PRE-HEARING STAFF ANALYSIS

Rezoning Petition No. 2008-064

Property Owner:	Chad Frazier, Porter Tiller, and Mark Palmquist
Petitioner:	Chad Frazier
Location:	Approximately 1.40 acres located on the west side of Frazier Avenue between W. 5 th and Martin Streets
Center, Corridor, or Wedge:	Wedge
Request:	R-5, single family residential to UR-1(CD), urban residential, conditional district

**RZ-1**  
**FRAZIER AVE.**  
**REZONING**  
**CHARLOTTE, NC**

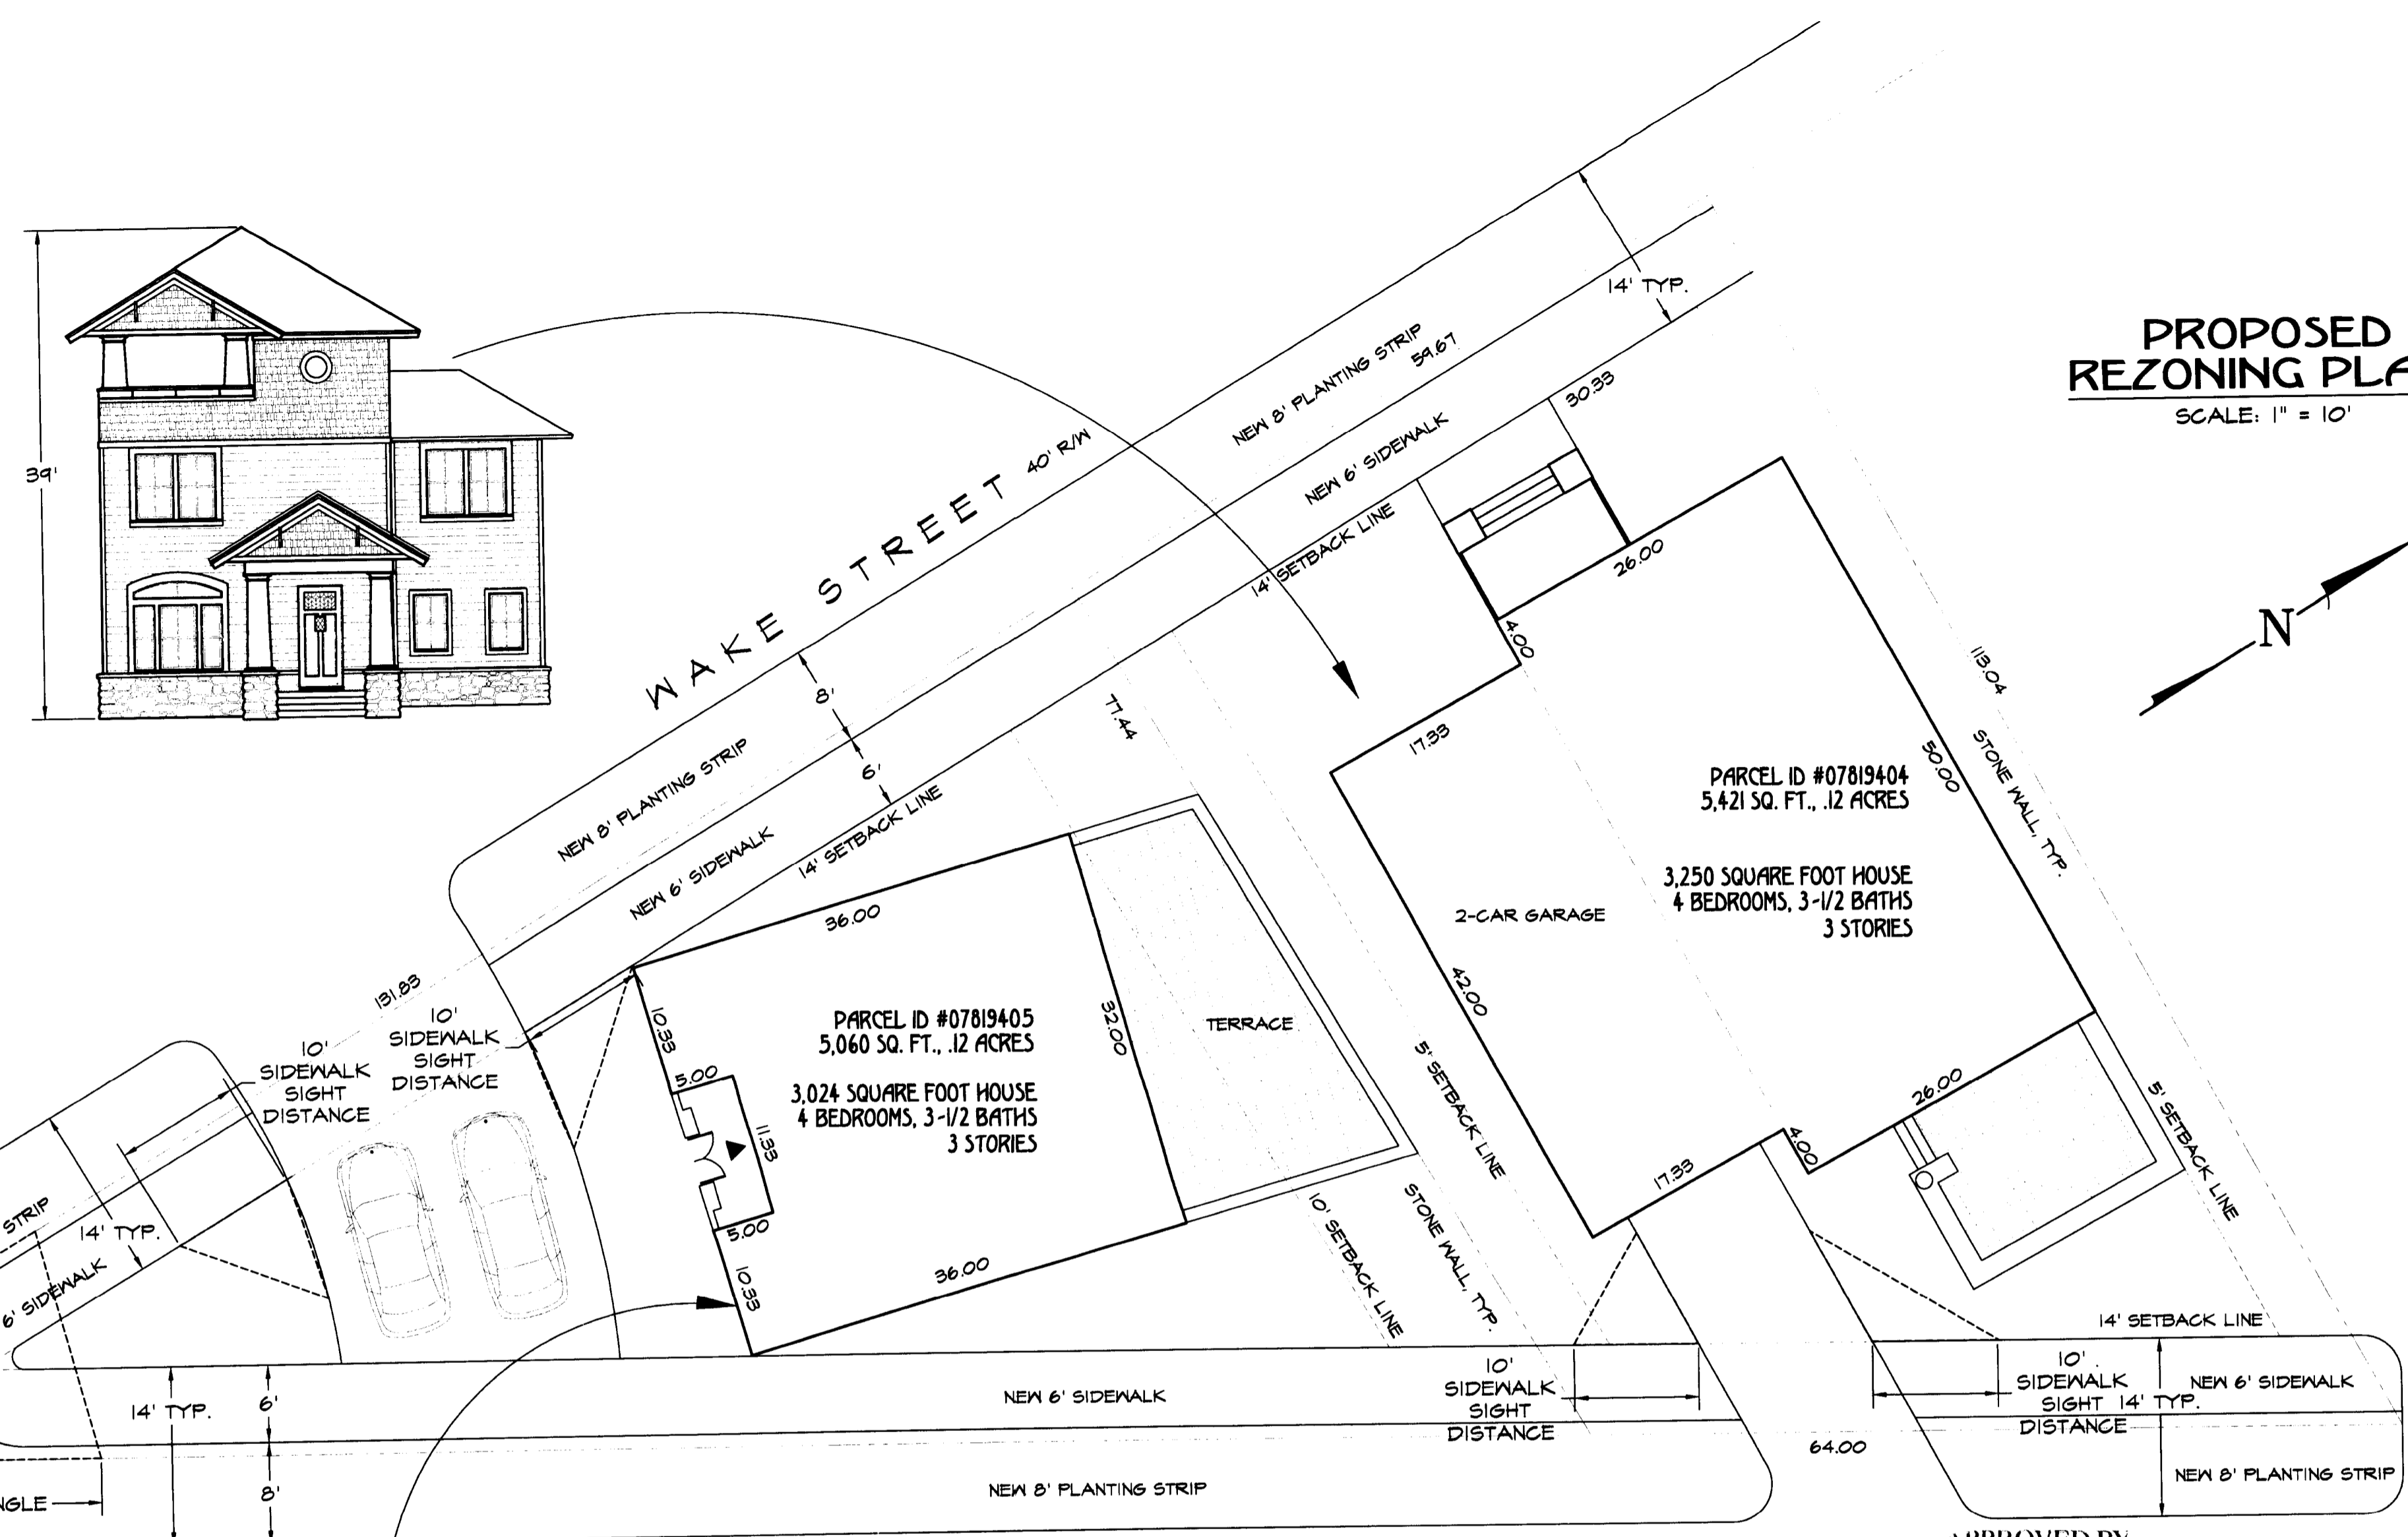
- Provision of planting strips and sidewalks along Wake Street, Frazier Avenue, and W. 5th Street.
- Provision of a minimum 20-foot offset between the back-of-sidewalk and the front of each garage to provide enough storage for a vehicle without blocking the public sidewalk.

- Removal of the proposed pull-through driveway located on tax parcel #07819405 at the corner Frazier Avenue and Wake Street, as CDOT can only support one driveway for this residential unit.

- Compliance with driveway design requirements.
- Proposed installation of stone walls are shown along the street frontages of several of the units and a requirement to obtain a permit from the CDOT.

- Provision of a 35-foot by 35-foot sight distance triangle at the intersections of Frazer Avenue/Wake Street and Frazer Avenue/ West 5th Street, and requirement for two 10'x10' pedestrian sight triangles for each driveway connection to meet minimum requirements.

- The petitioner should note *Rezoning Petition 2008-064* on the site plan.
- The plans still show two driveways are proposed for Parcel ID 07819405. CDOT has indicated that only one (1) driveway will be supported for this residential unit.
- Petitioner should confirm with CDOT there are no plans to widen any of the right-of-ways.
- The petitioner should revise the plans to show existing driveways in the immediate vicinity to ensure there are no conflicts.
- The petitioner should provide a 20-foot distance between back of sidewalk and garage.
- The petitioner should add site distance triangles to the site plan.
